Our Ref: BR/63/19/PL

**Town & Country Planning Act 1990 (as amended)
Town and Country Planning (Development Management Procedure) (England) Order 2015
Application for Planning Permission**

Development Demolition of existing building and erection of 6No. three bedroom dwellings with associated accesses and car parking.

Location 15-17 Kew Gardens Bognor Regis

BLOCK PLAN (1:500)

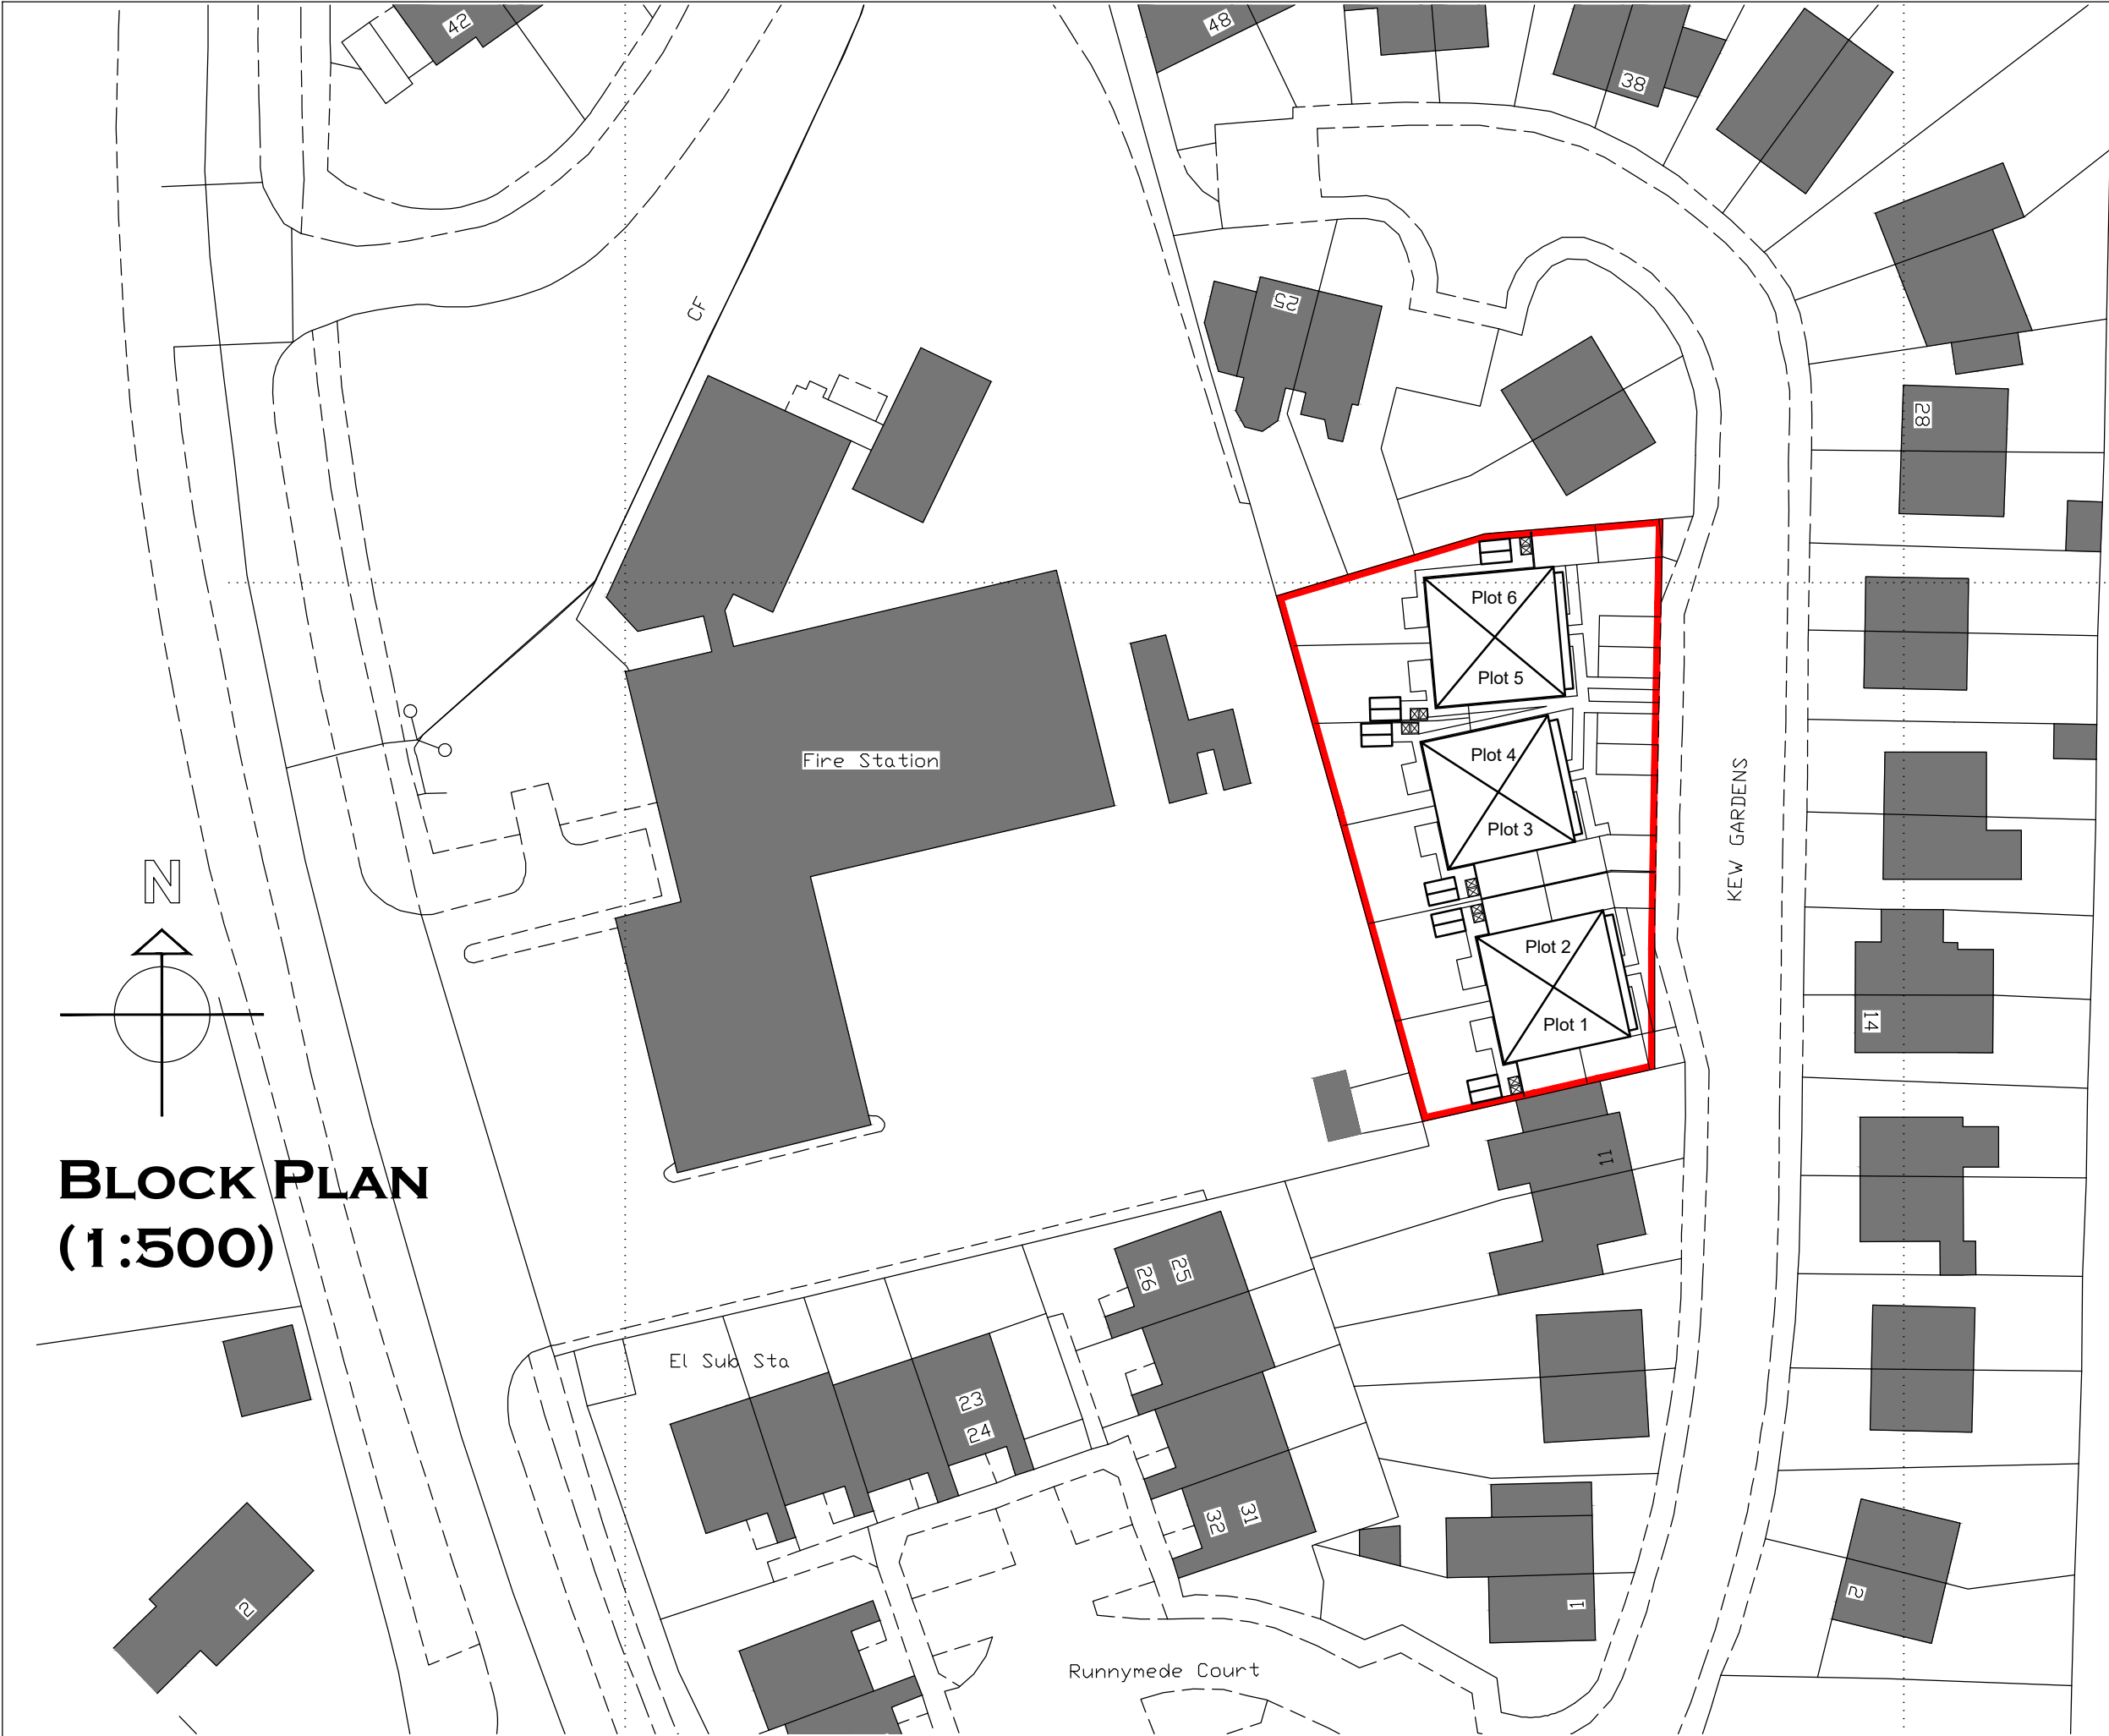
Block Plan

Please submit 1 electronic or 3 paper copies of an amended block/site plan at a scale of 1:500 or 1:200 to show visibility splays from access points

Project:-			
Proposed Residential Development 15-17 Kew Gardens Bognor Regis West Sussex			
Title:-			
Site Location Plan			
Client:-			
Farnden Developments Ltd			
Scale:-			
1:1250 (@A3)			
Drawn By:-	PJD	Checked By:-	
Date:-	14/02/19	Date:-	
Job.No:-	180037	Drg.No:-	01
Rev:-

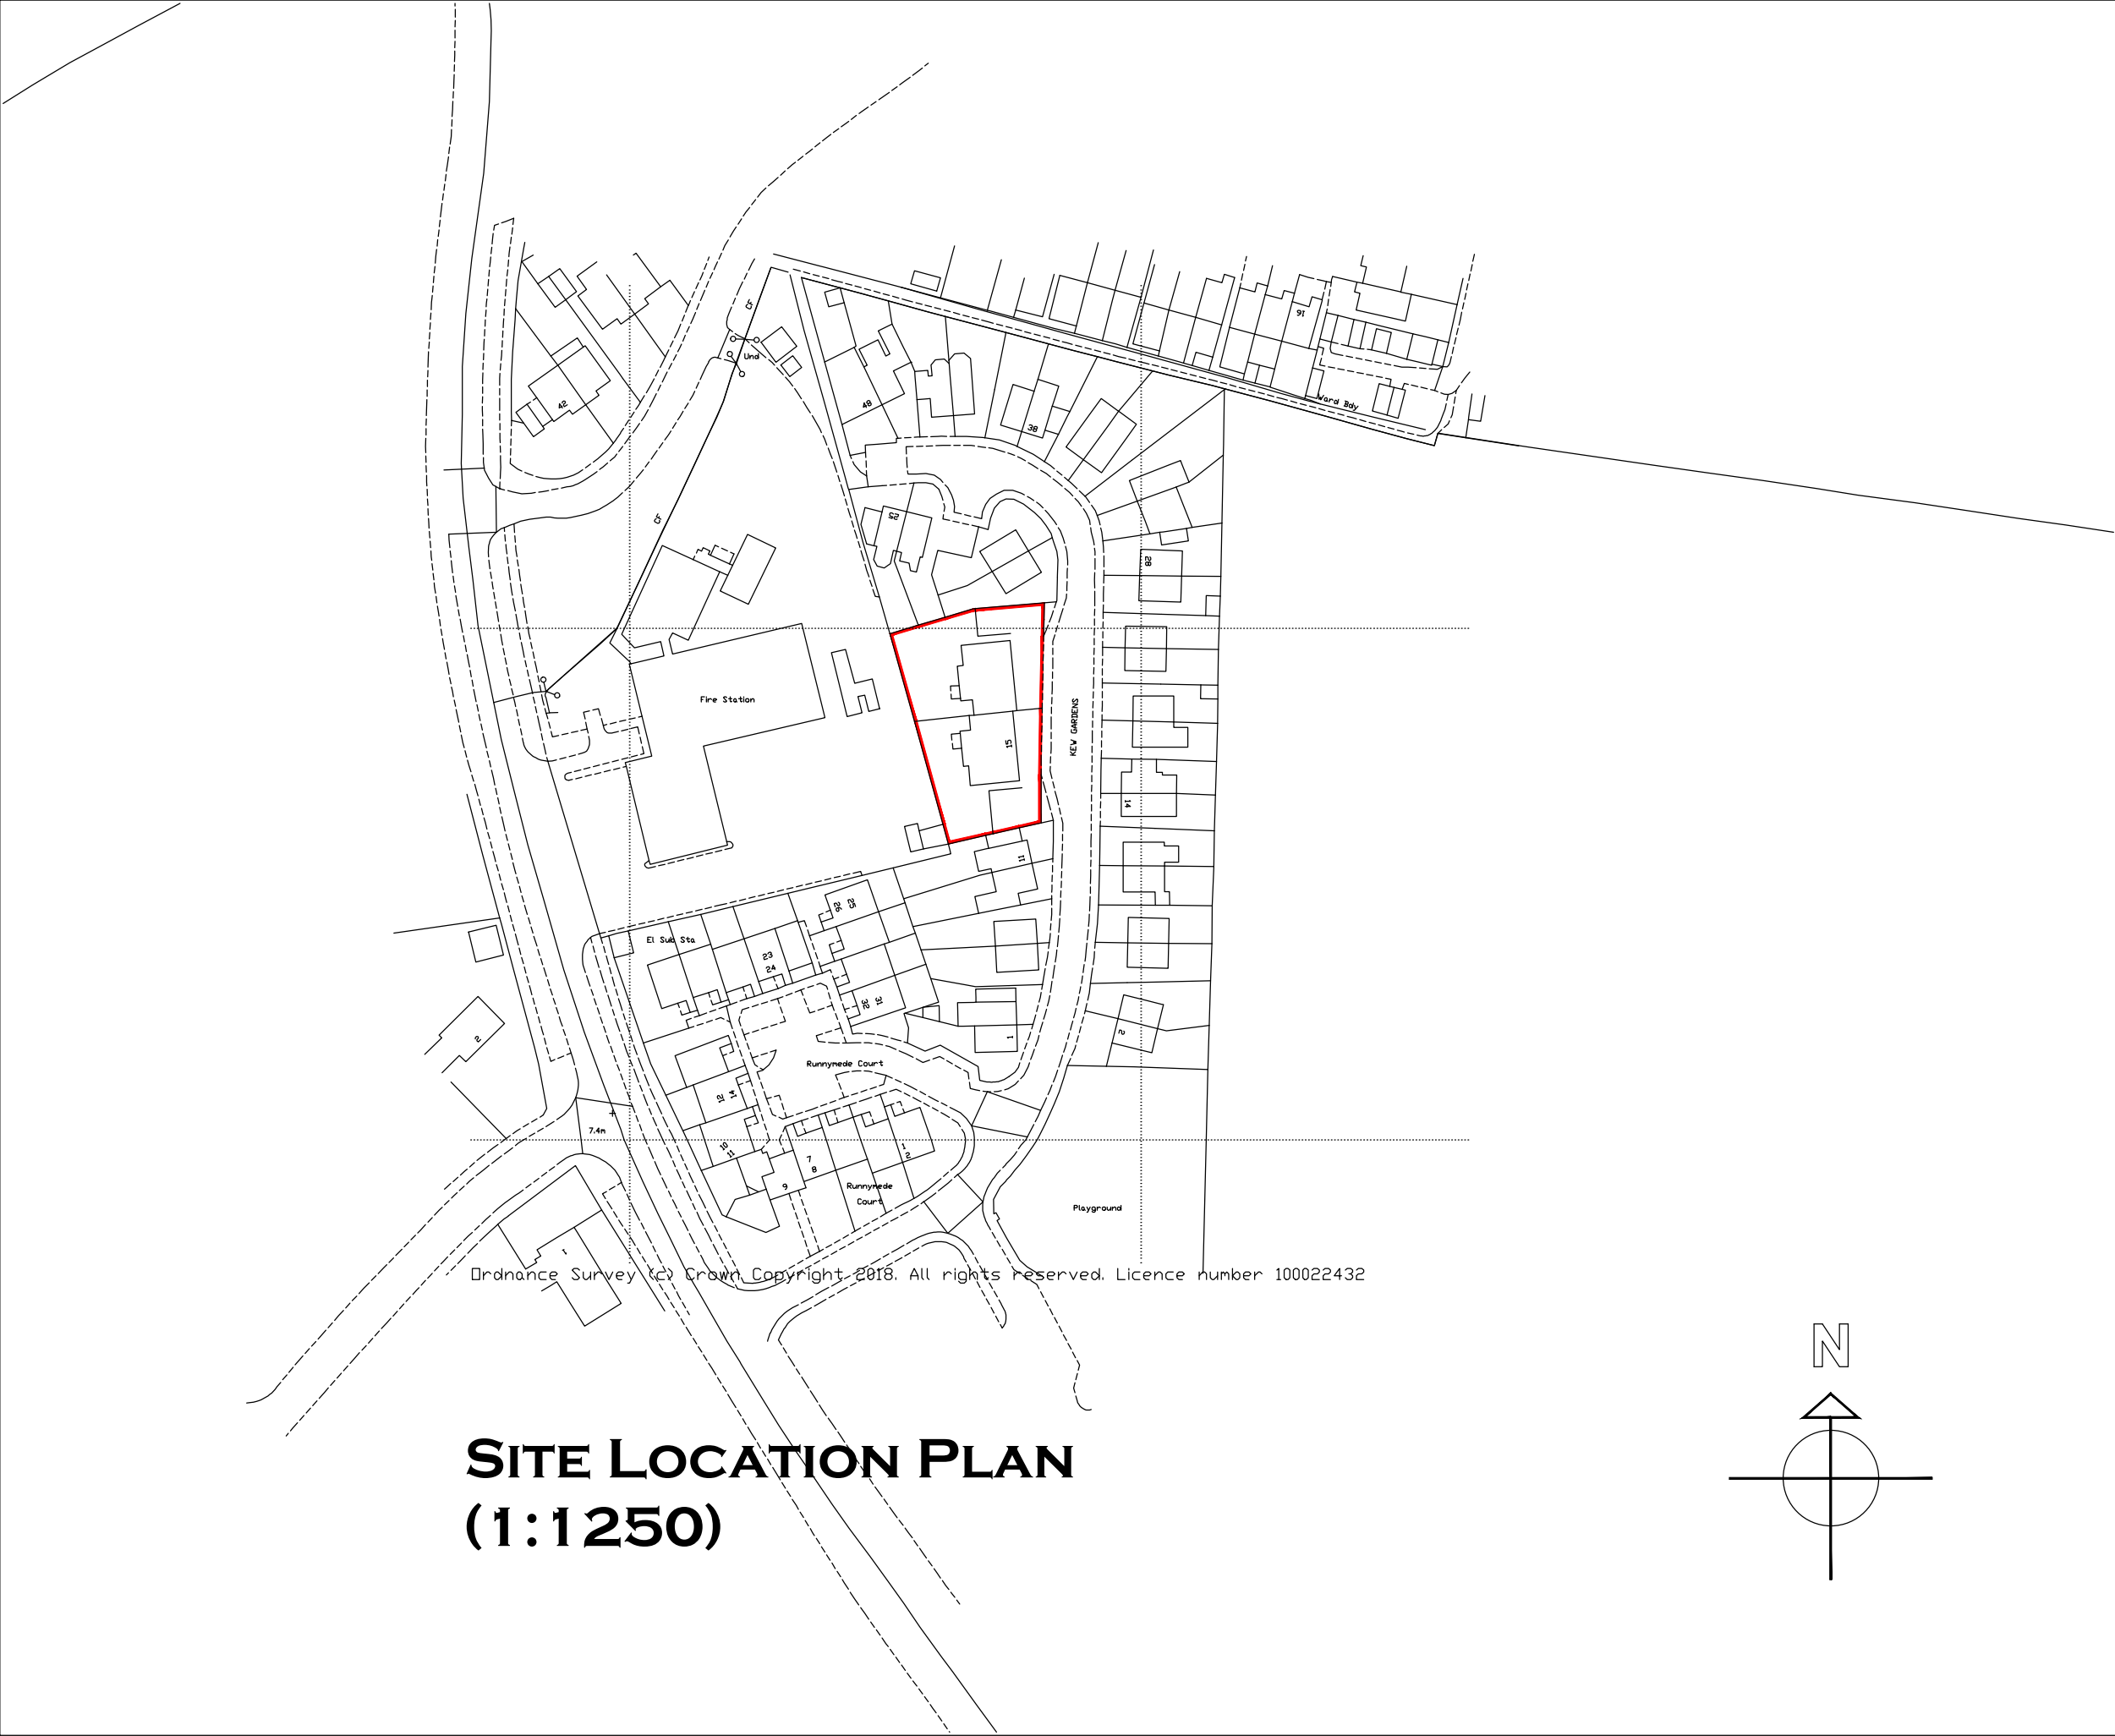
Location Plan

Please submit 1 electronic or 3 paper copies of an amended location plan at a scale of 1:1250 or 1:2500 for rural areas to include highway land edged in blue. You will also need to serve notice on West Sussex County Council Highways land and update Certificate B to show this.
